RE: **Behavioral Health Hospital**  
**1525 Renaissance Blvd NE**  
**Grading Plan Stamp Date: 1/16/19**  
**Drainage Report Stamp Date: 1/16/19**  
**Hydrology File: F16D051A**

Based on the submittal received on 1/18/19, the grading plan and drainage report are approved for Building Permit.

**RE: BEHAVIORAL HEALTH HOSPITAL  
GRADING AND DRAINAGE PLAN RESPONSE TO COMMENTS  
ENGINEER'S STAMP DATE 10/1/2018 (F16D051A)**

## **Behavioral Health Hospital Tract 9A-1B Renaissance Center**

BEHAVIORAL HEALTH HOSPITAL RENAISSANCE CENTER CROSS SECTIONS AND ADA DETAILS TERRA WEST, LLC 5571 MIDWAY PARK PLACE NE ALBUQUERQUE, NM 87109 (505) 858-3100 www.tierawestllc.com	DRAWN BY DY
		DATE 9/26/18
		2017054—SECTIONS
		SHEET # C4 JOB # 2017054

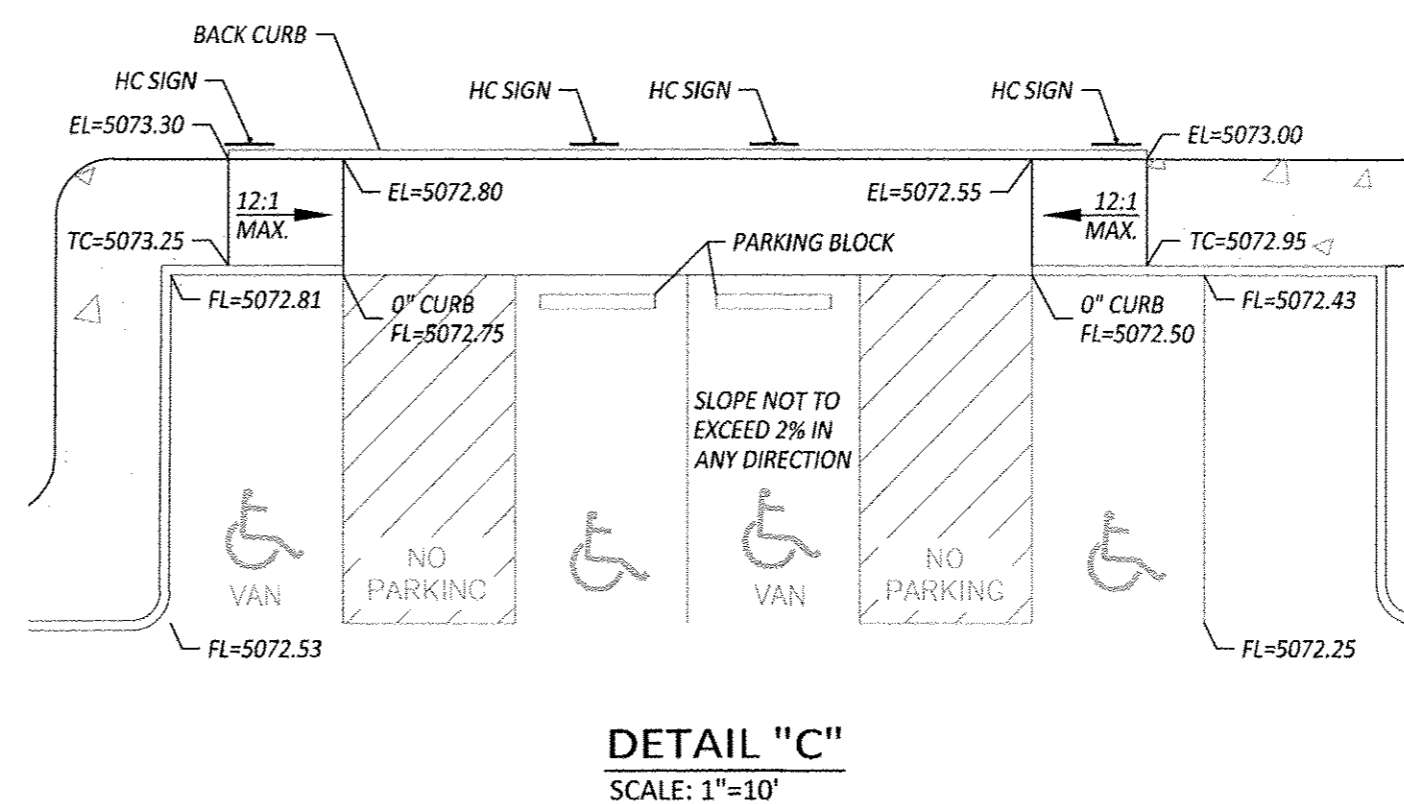
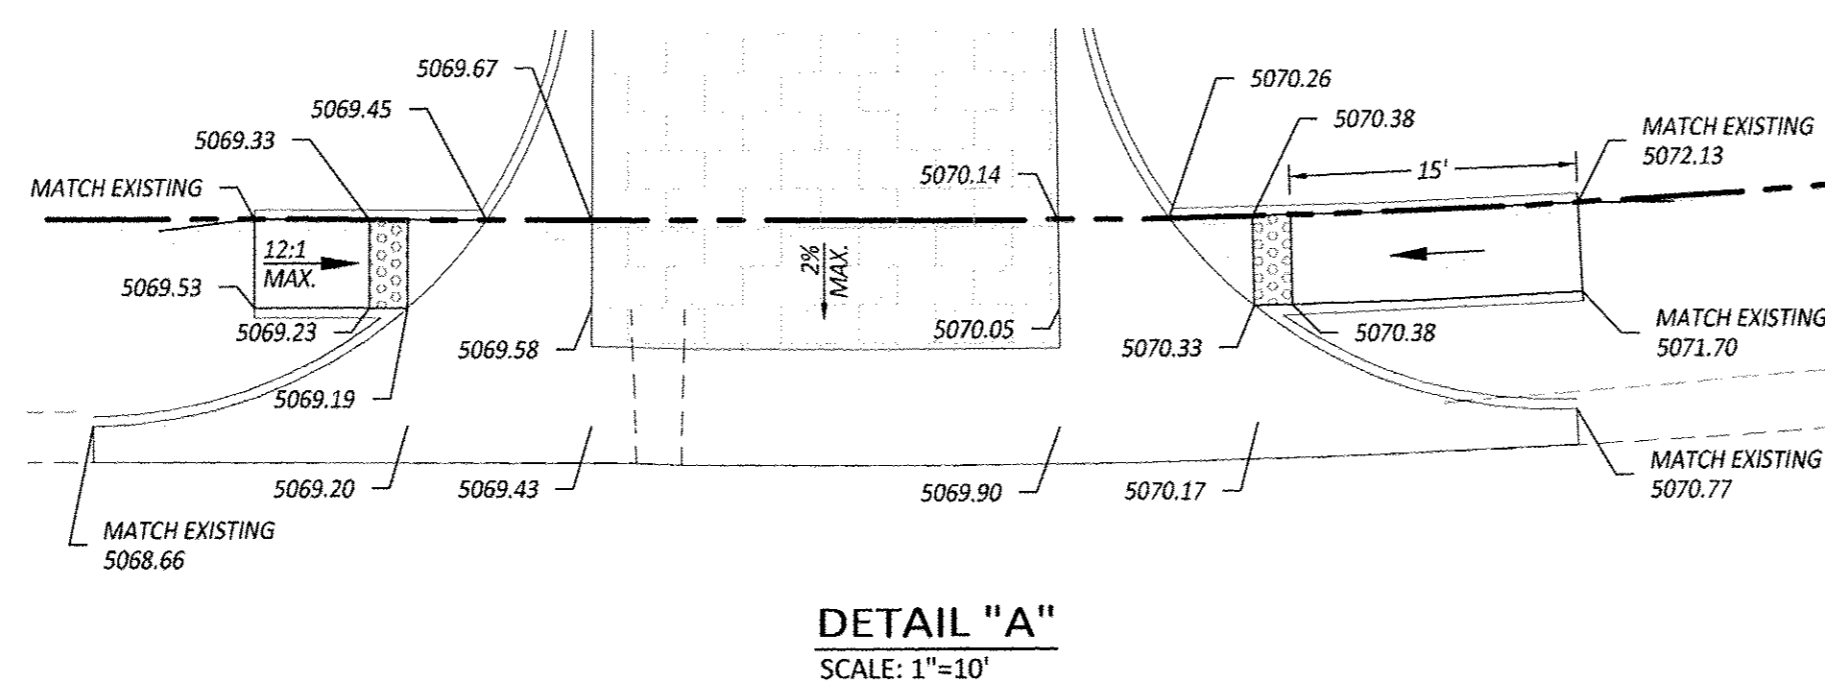
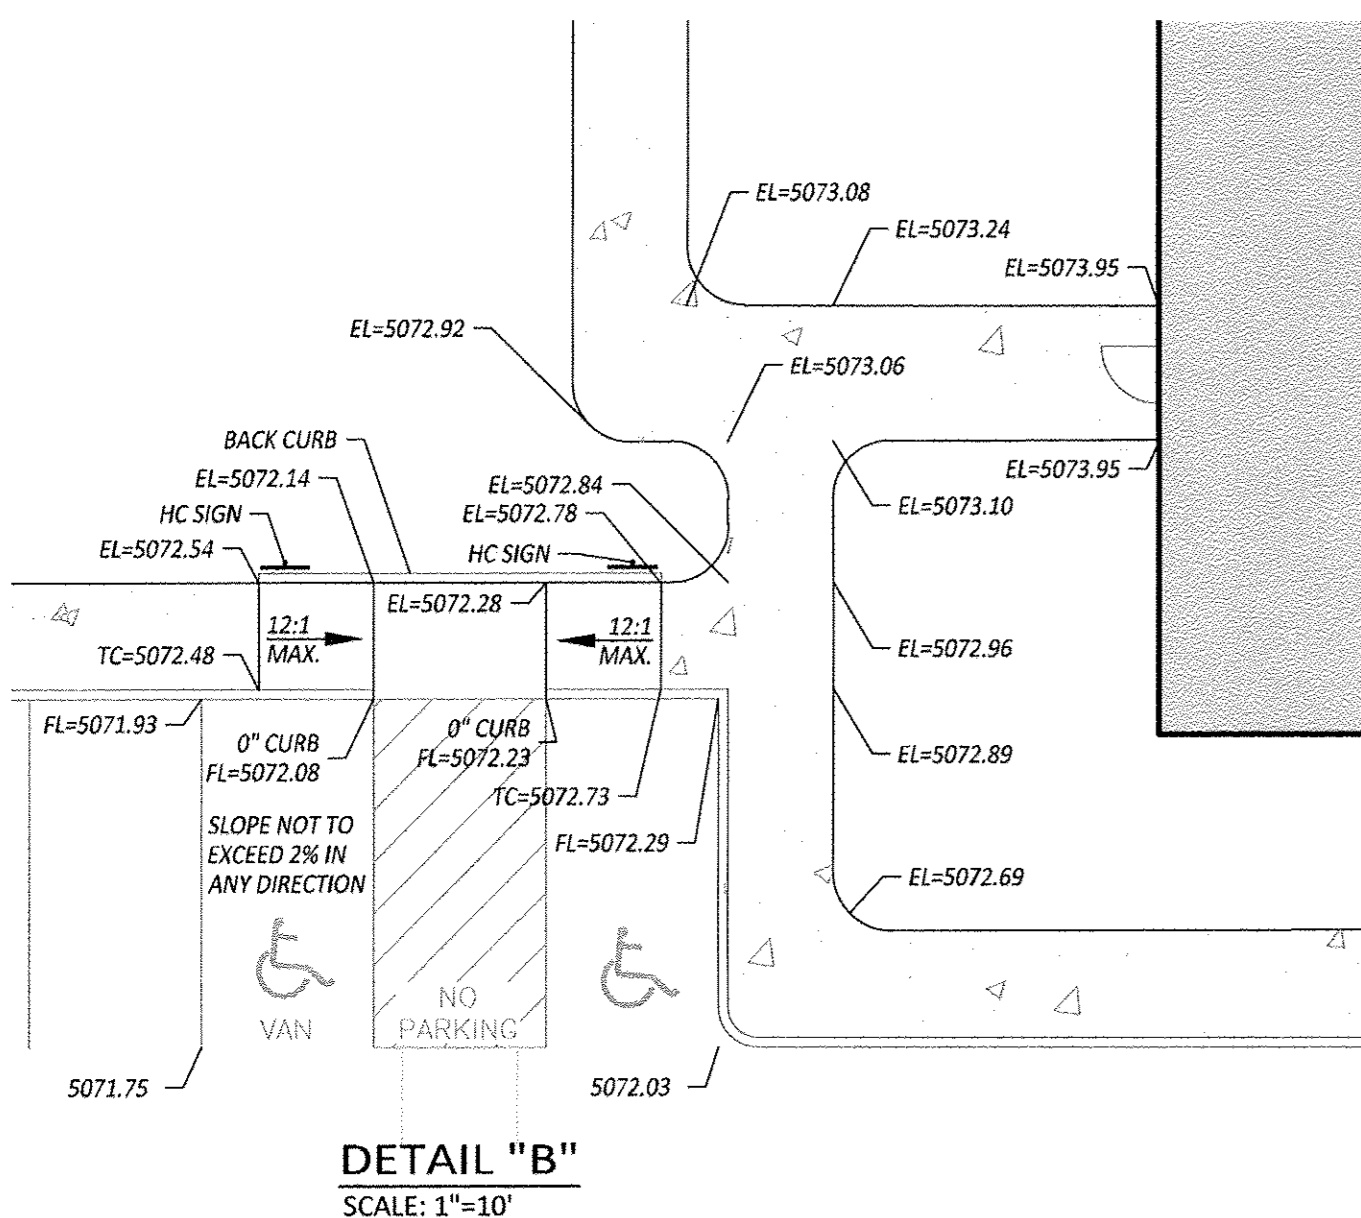
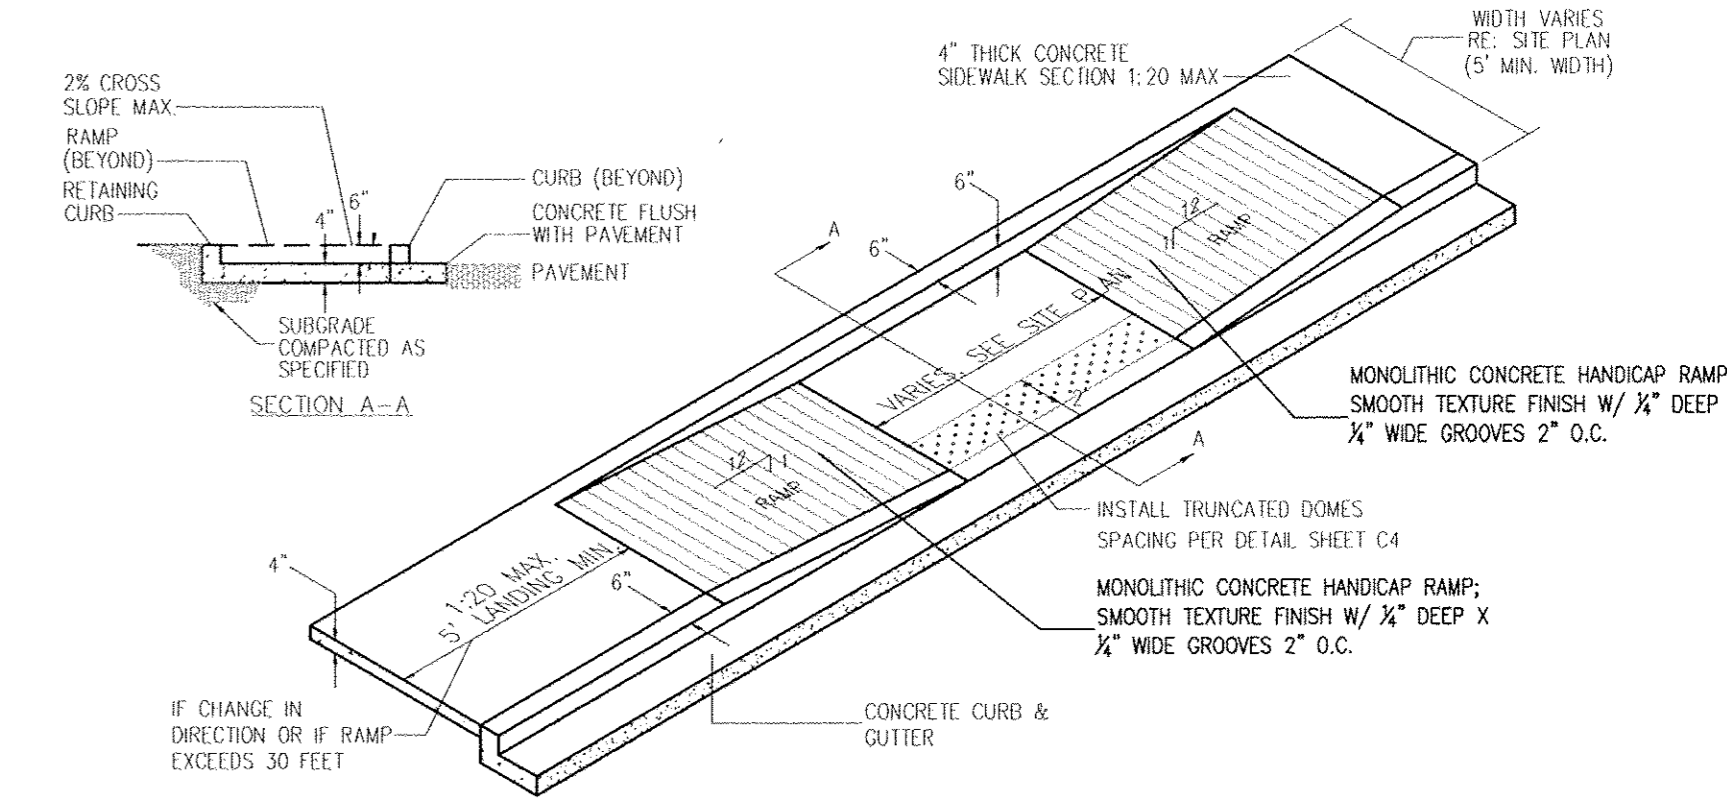
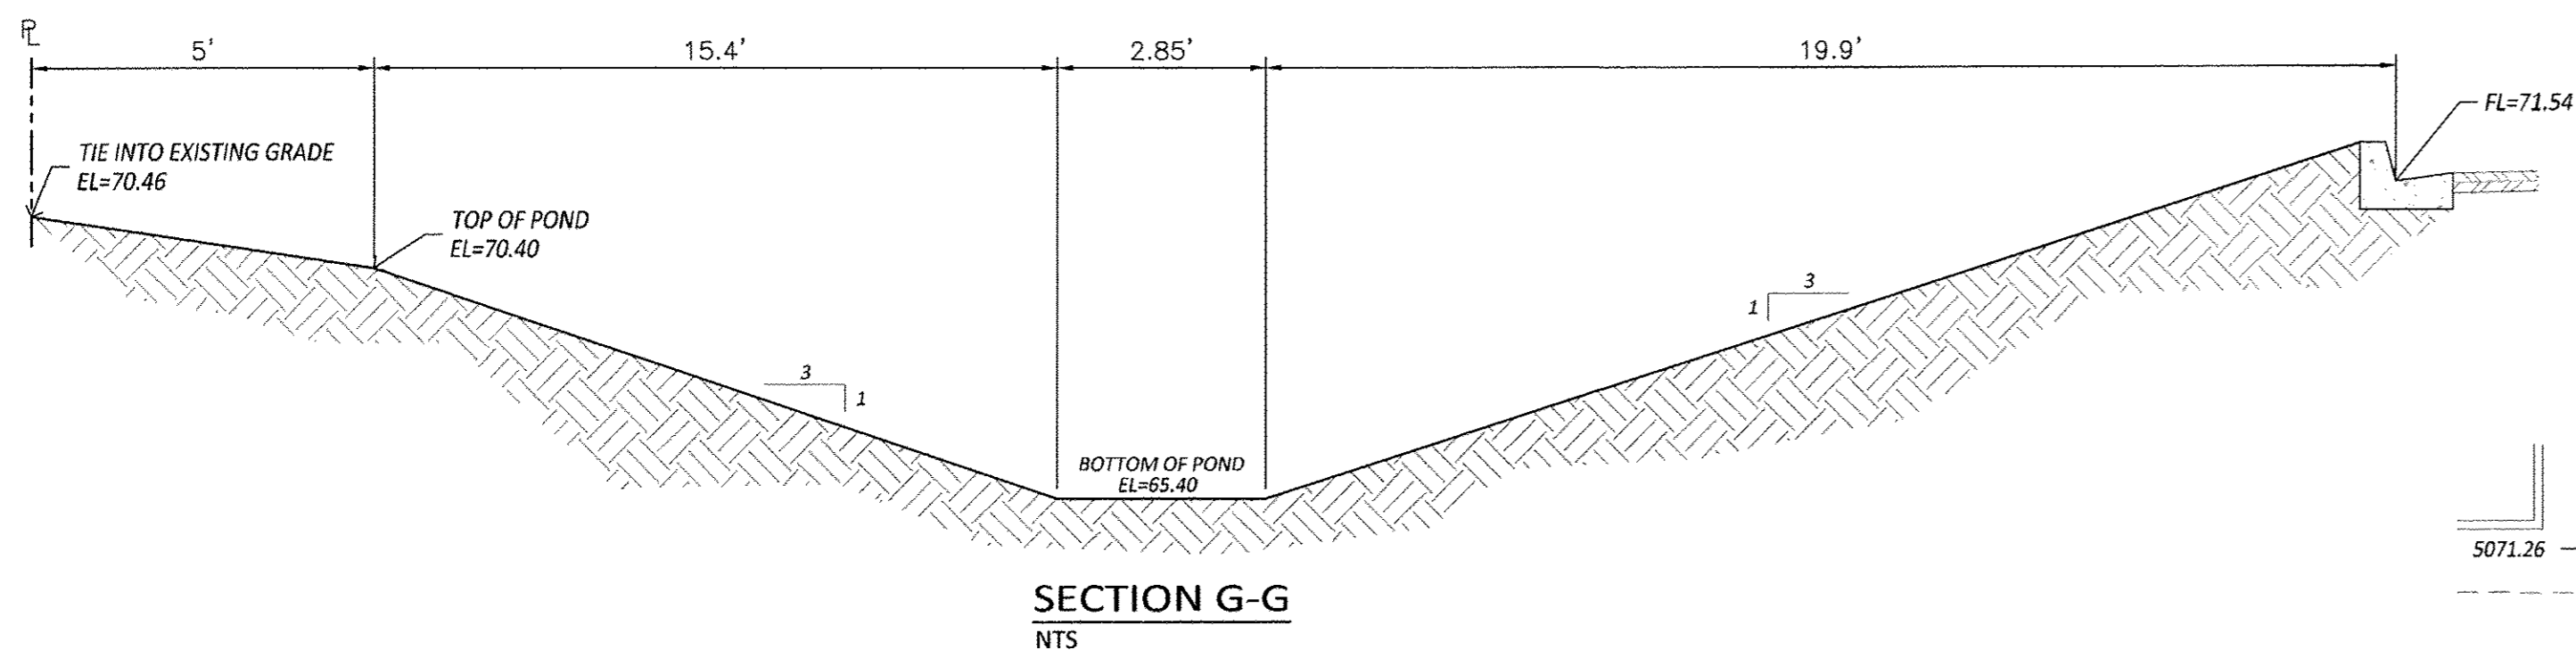
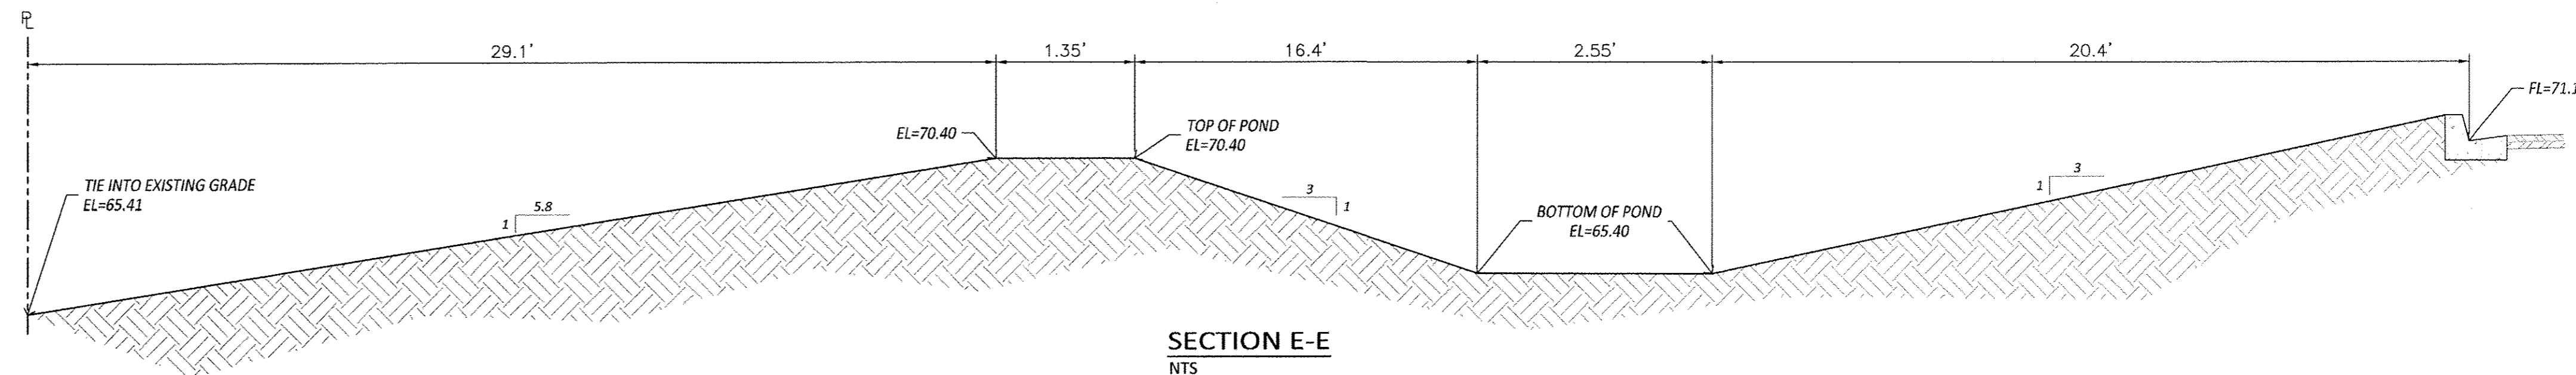
4. If these sloped areas are to be landscaped (w/gravel mulch) please state on plans; otherwise annotate that disturbed areas are to be reseeded per Std Specification Section 1012.

7. Provide sections through the ponds and across the property line onto FedEx. Show 100-yr water surface elevations, tops and bottoms of berms. What design considerations were made to ensure FedEx is protected by the proposed berms? Hydrology recommends following levee and berm criteria per DPM Ch22.3.F.

8. Provide emergency spillways for the ponds, sized for the 100-yr storm inflow, or provide 2x capacity in the discharge pipes. Show the 100-yr and first flush water surface elevations for the ponds.

**Response: The cross sections on Sheet C4 have called out gravel mulch and to refer to landscape plans on all the sloped areas shown.**
5. Call out Std Dwg 2426 and 2420 for the drive entrance.

**Response: Sections F-F and G-G have been extended to the FedEx side to show the concrete slope and elevation callouts on the FedEx side of the property line. Sections E-E and G-G have also been updated to show the 100-year MWSE as well as the First Flush water surface elevations.**

Design considerations for prevention of runoff overtopping the west property line to FedEx were considered in the maximum water surface elevation of the ponds. The ponds provide a freeboard with respect to the west property line of 1.8'. The lowest point of the existing grade along the west property line is at the NW corner. The grading has been updated with a small retaining wall to lift this corner area to provide the 1.8' of freeboard consistently across the west property line. The addition of a concrete-lined emergency overflow with riprap rundown and with an overflow invert approximately 1.8' below the west property line will also assure that any buildup of drainage in the ponds will exit through the overflow before overtopping the property line.

The pond bottom has also been lowered to an elevation of 65.00 to allow for more freeboard and storage than the initial drainage pond design. Updates to the pond table, pond schematic, and AHYMO modeling results are included in Appendix D.

**Response: An emergency overflow has been added to the south side of the SW pond. Since both the NW and SW ponds act as one singular pond together, only one overflow was necessary. The overflow has been sized to accommodate the 100-yr storm inflow to the ponds (26.54 cfs). Overflow will be lined with concrete and riprap rundown pad added to the downstream side of overflow and towards Renaissance Blvd. Plan view detail can be found Sheet C3 and a cross sectional view can be found on Sheet C4. Capacity calculations can be found in Appendix C.**
